From: Neeltje Chappell <nc@hdarchitects.co.uk>
Sent: 19 March 2024 16:40
To: Tom Nemeth
Subject: [EXTERNAL] RE: WE/24/00546/DOM
Attachments: 23073-001B.pdf; 23073-003C.pdf; 23073-002A.pdf

From: Tom Nemeth <tnemeth@chichester.gov.uk>
Sent: Tuesday, March 19, 2024 4:23 PM
To: Neeltje Chappell <nc@hdarchitects.co.uk>
Subject: RE: WE/24/00546/DOM

23073 – 12 New Road, Westbourne

DATE Dec-23	DRAWN NC
DRAWING No. 23073 - 003	REV C

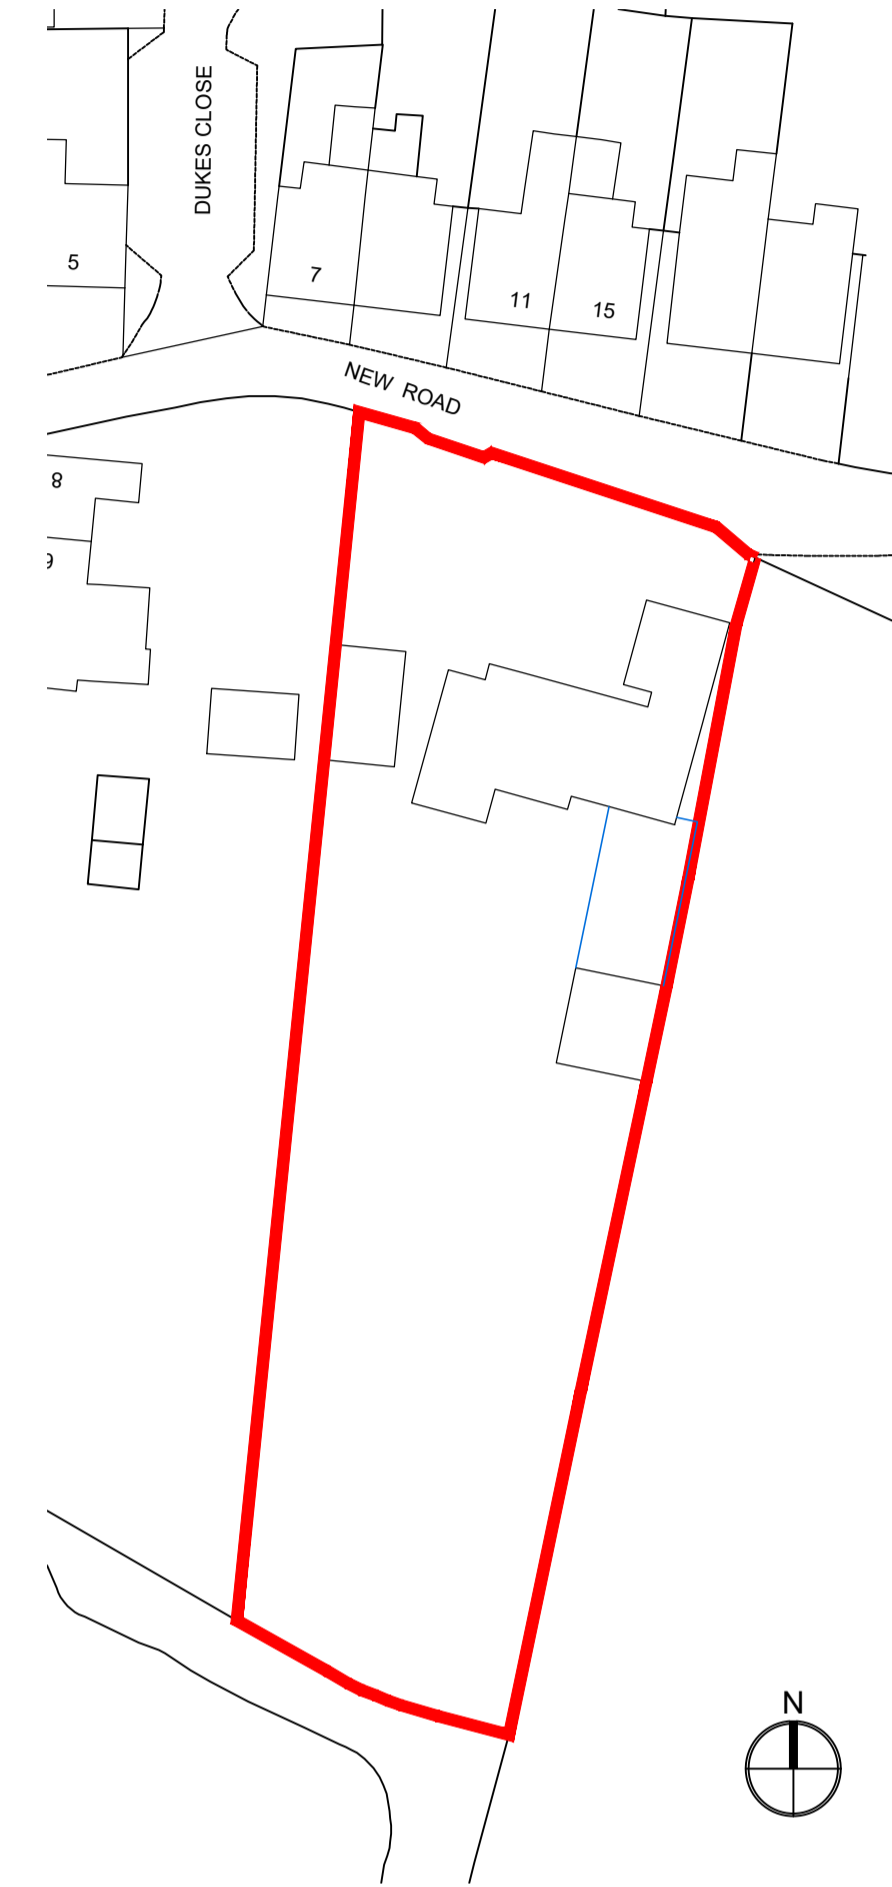
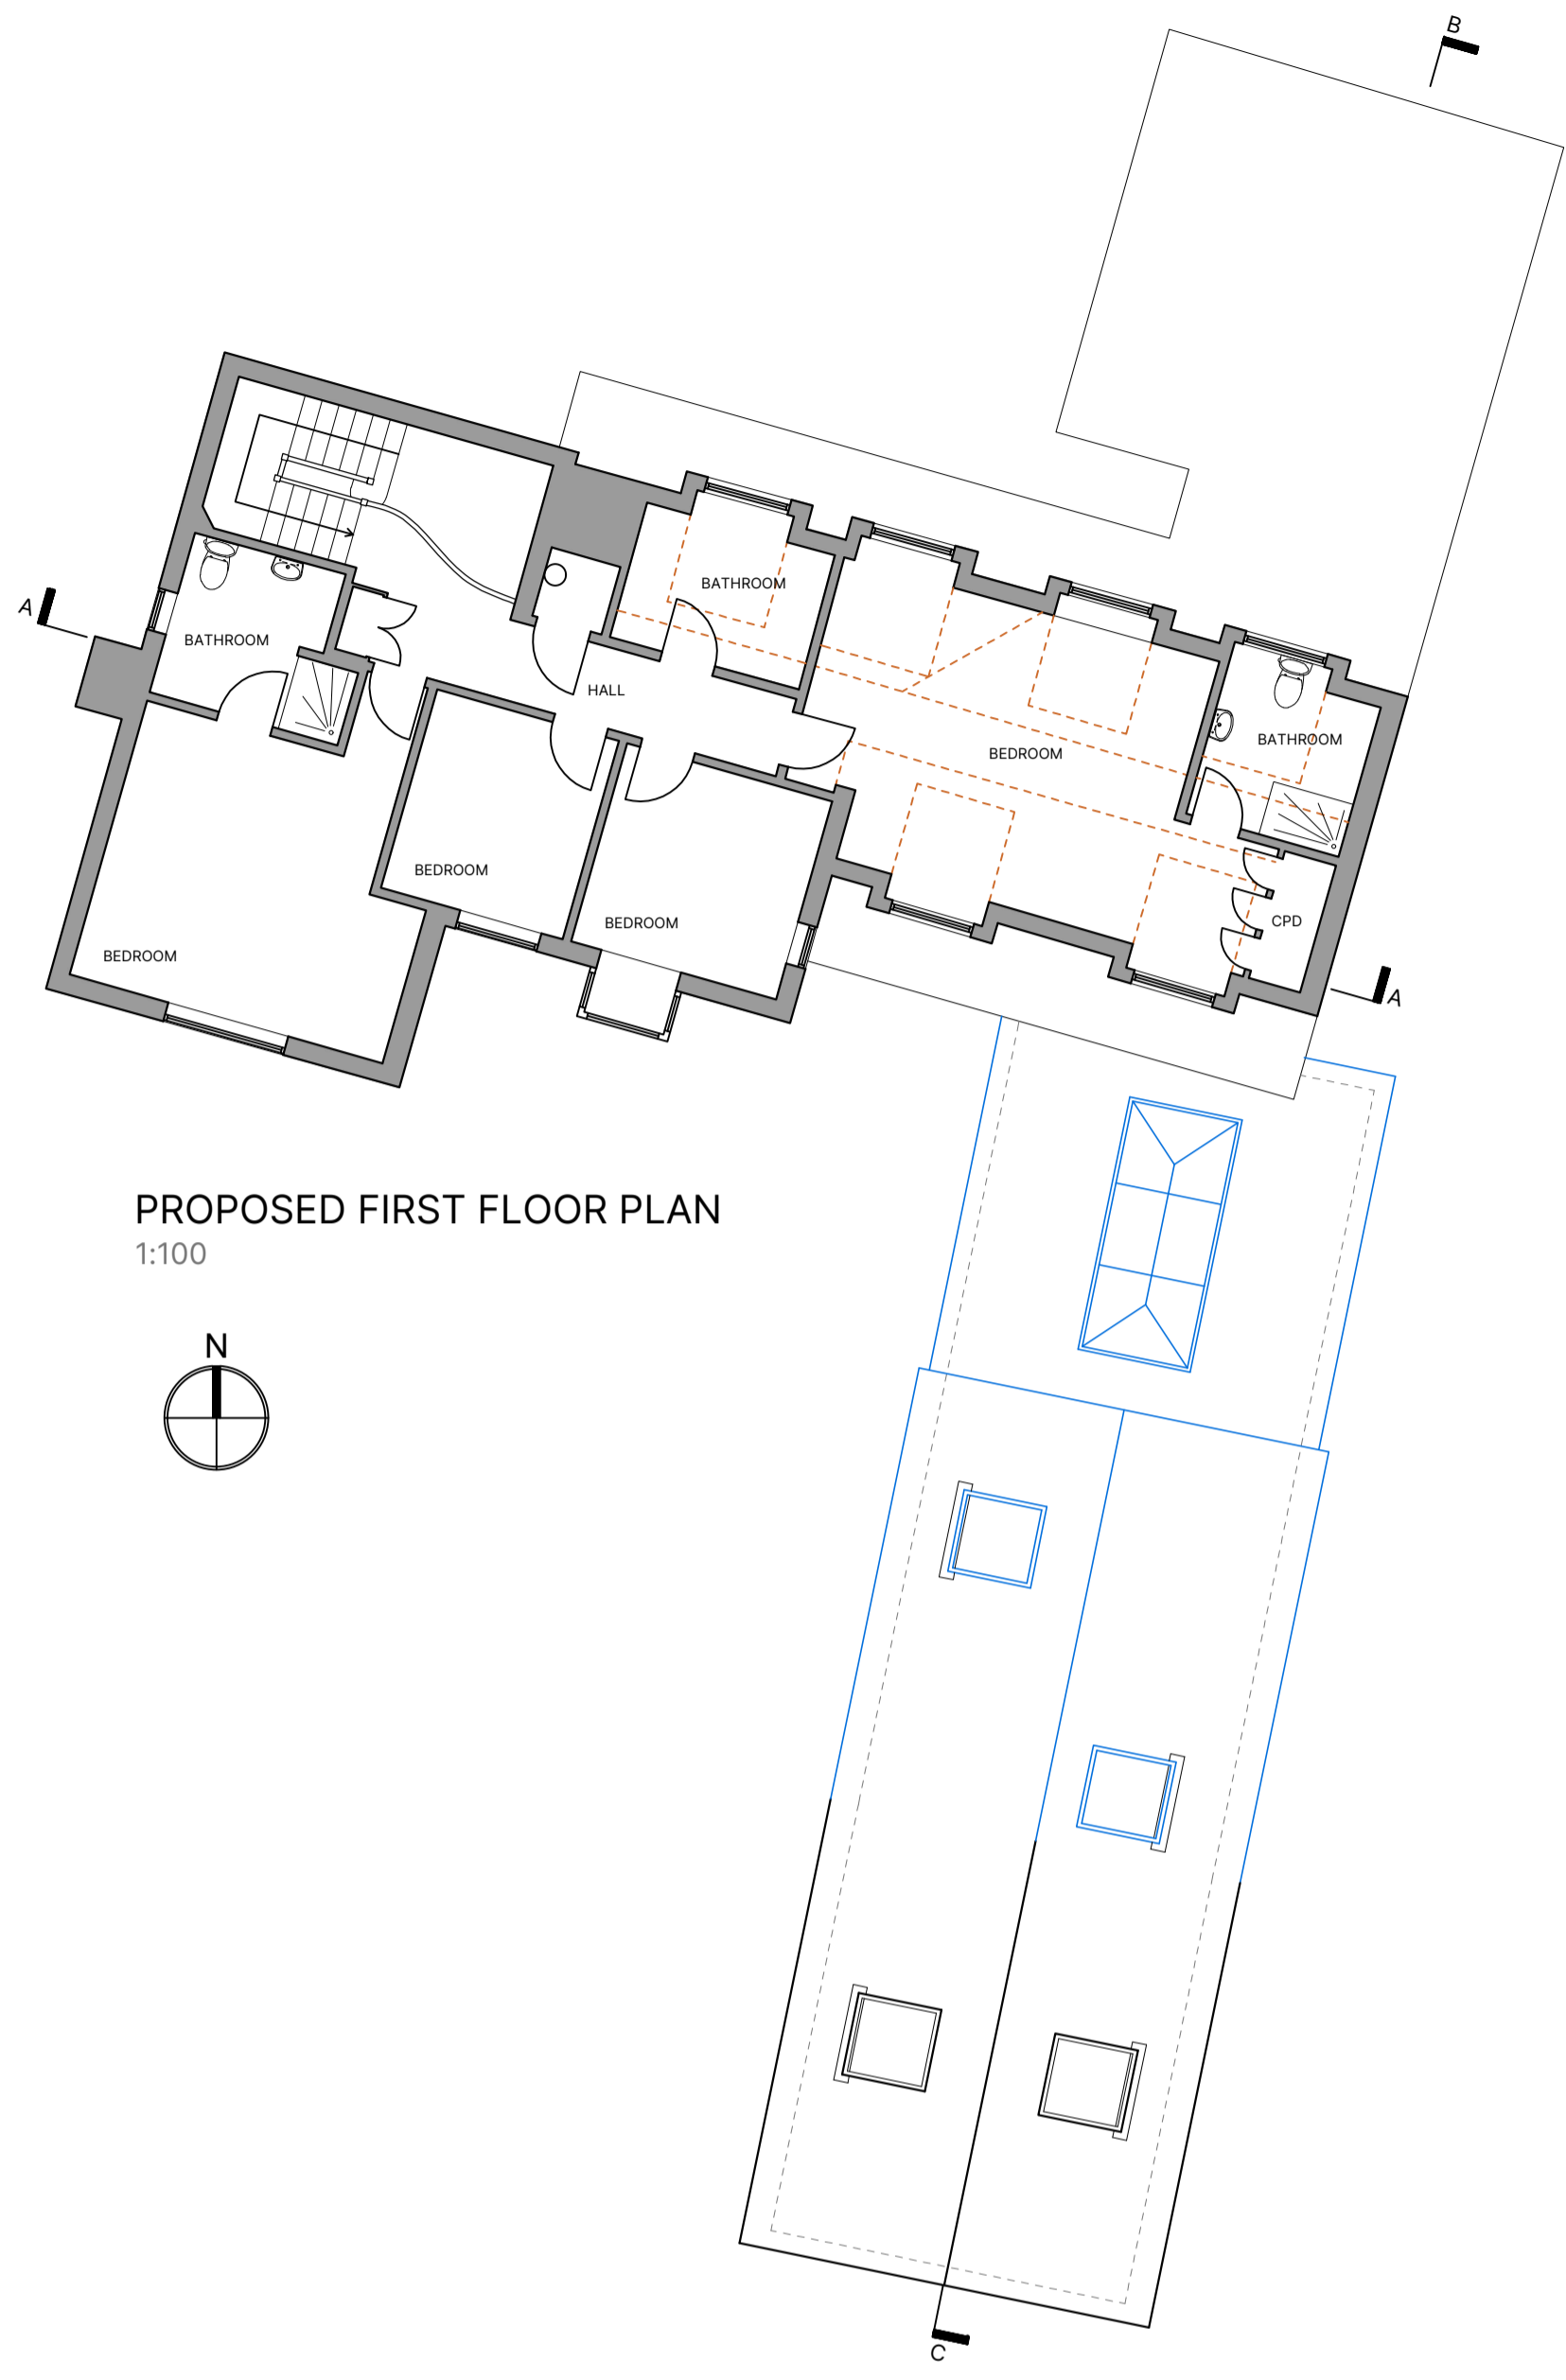
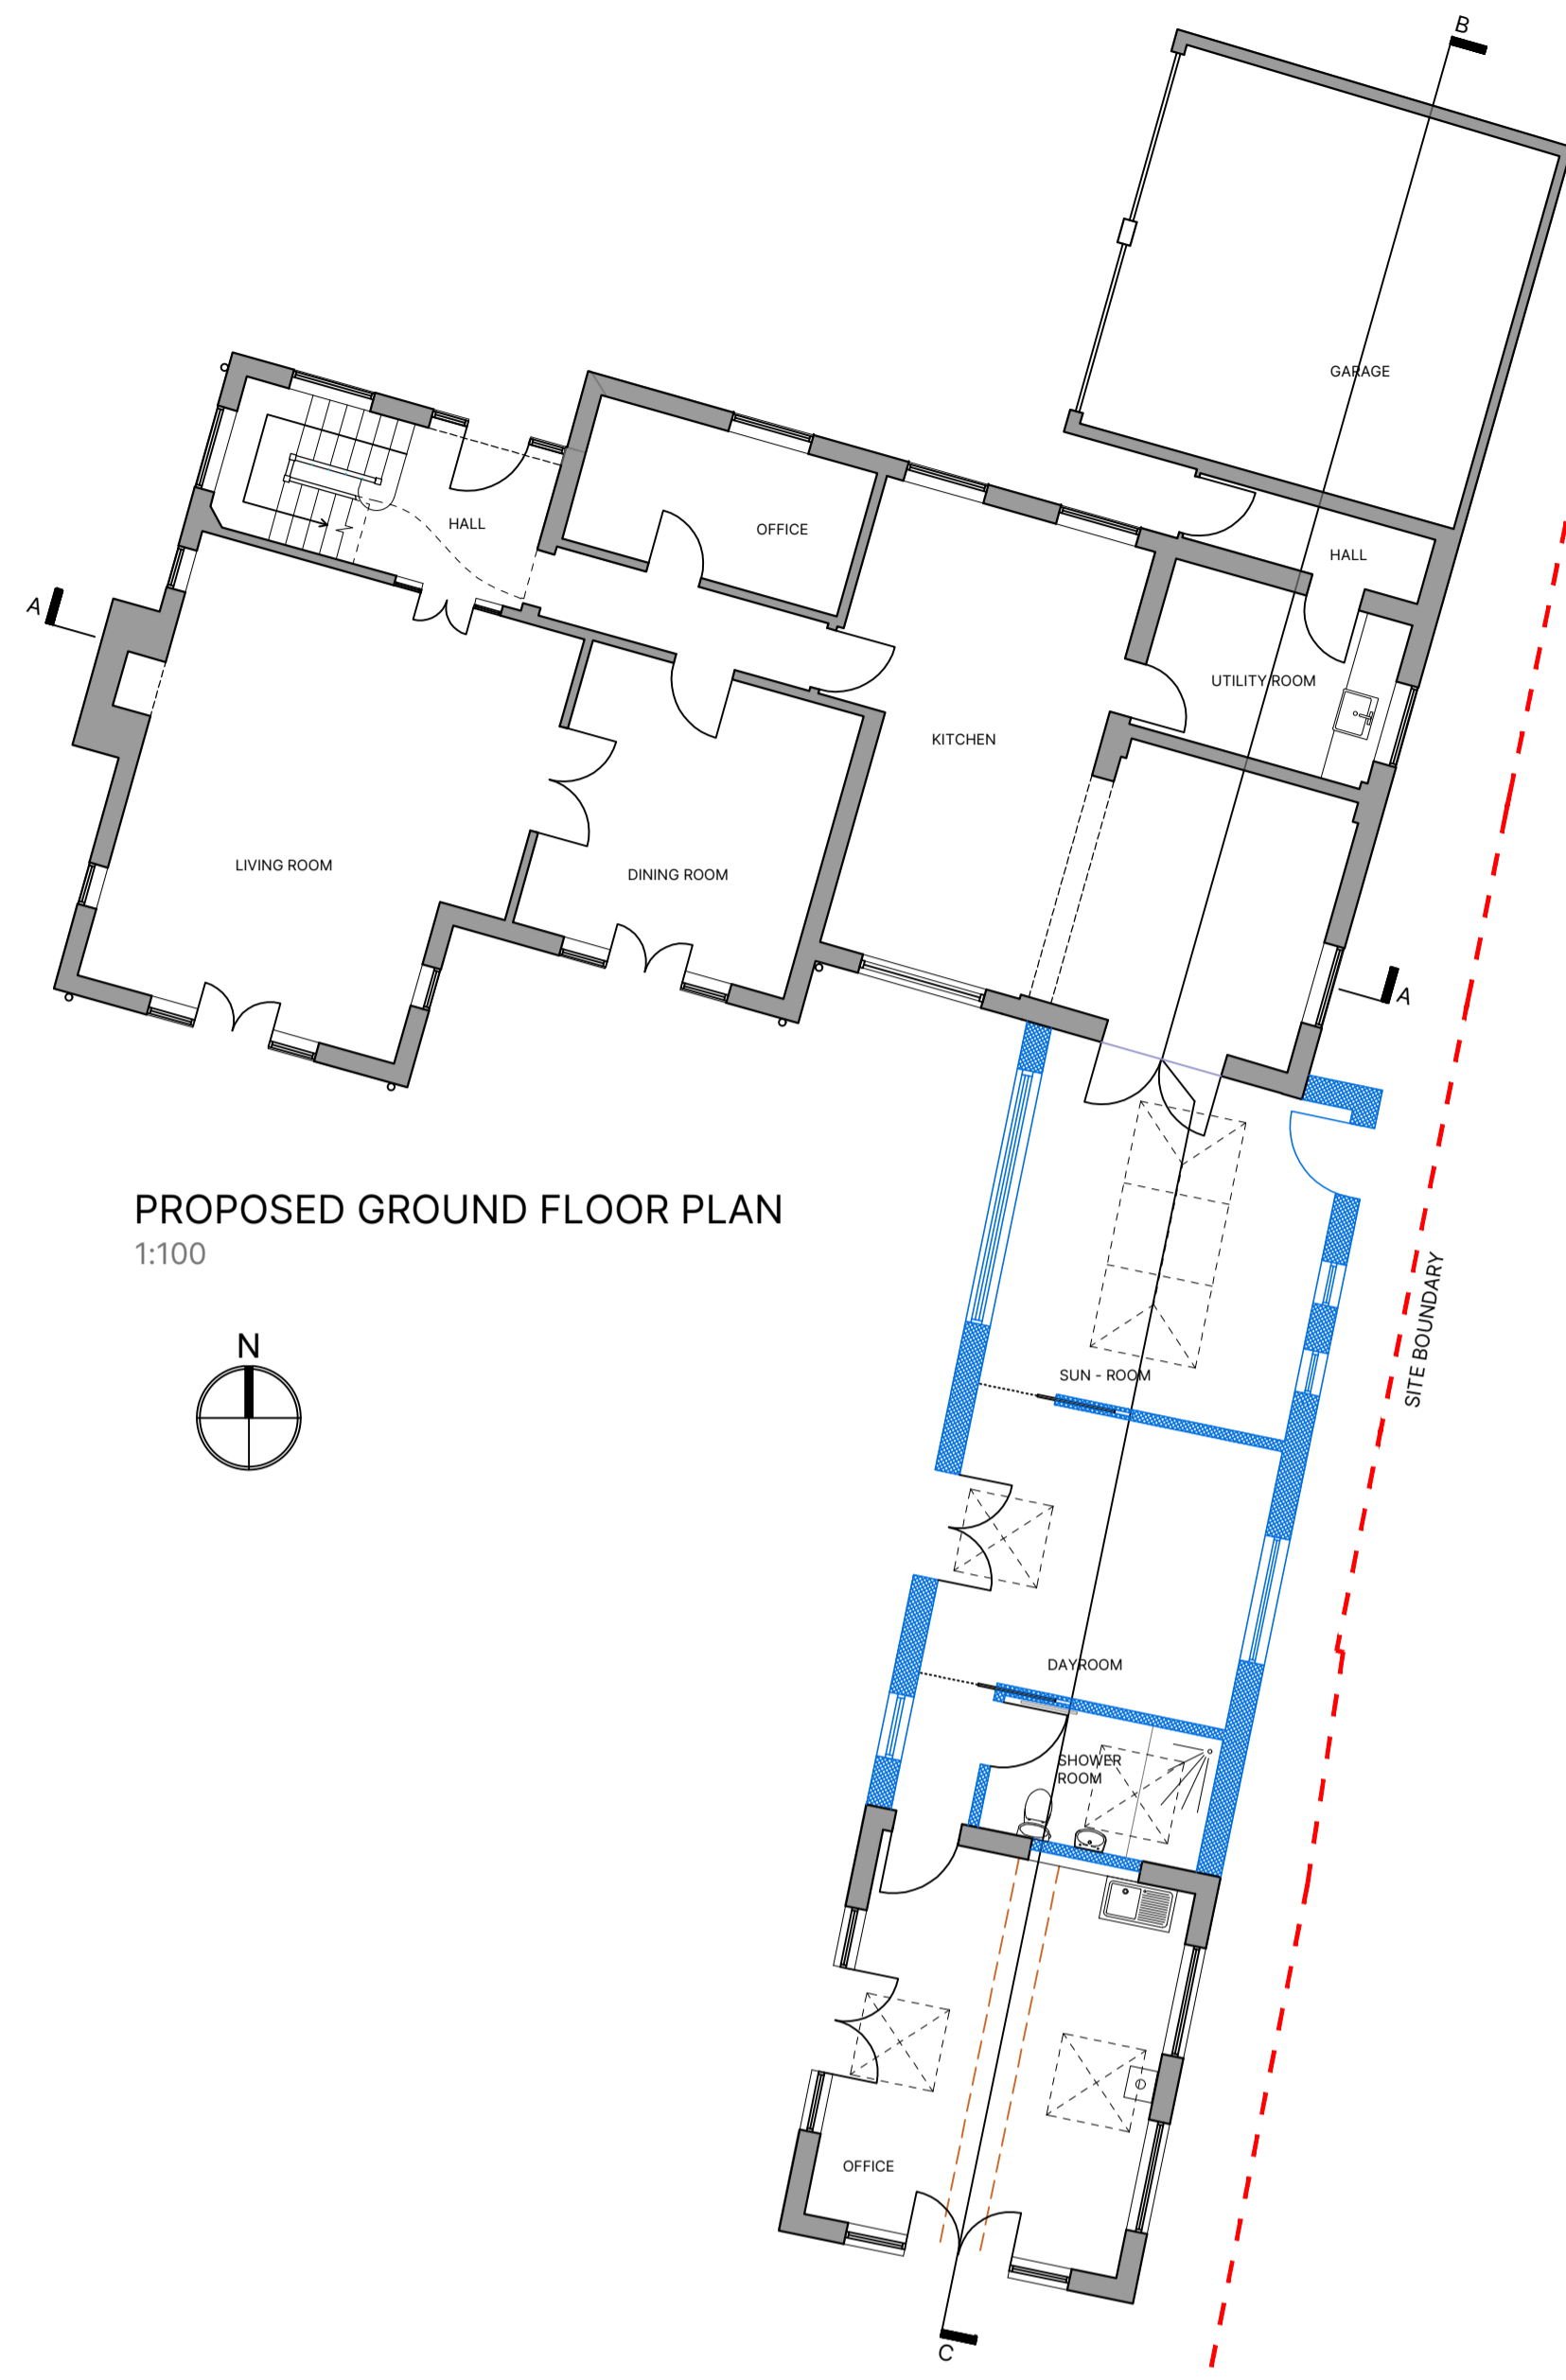
Drawing 23076-003 REV A - add a red line around the domestic curtilage/property boundaries on the proposed block plan and add a north point to the proposed floor plans.

Thank you for your email. Please find attached the revisions as requested.
If there is anything else you need, please don't hesitate to contact me.
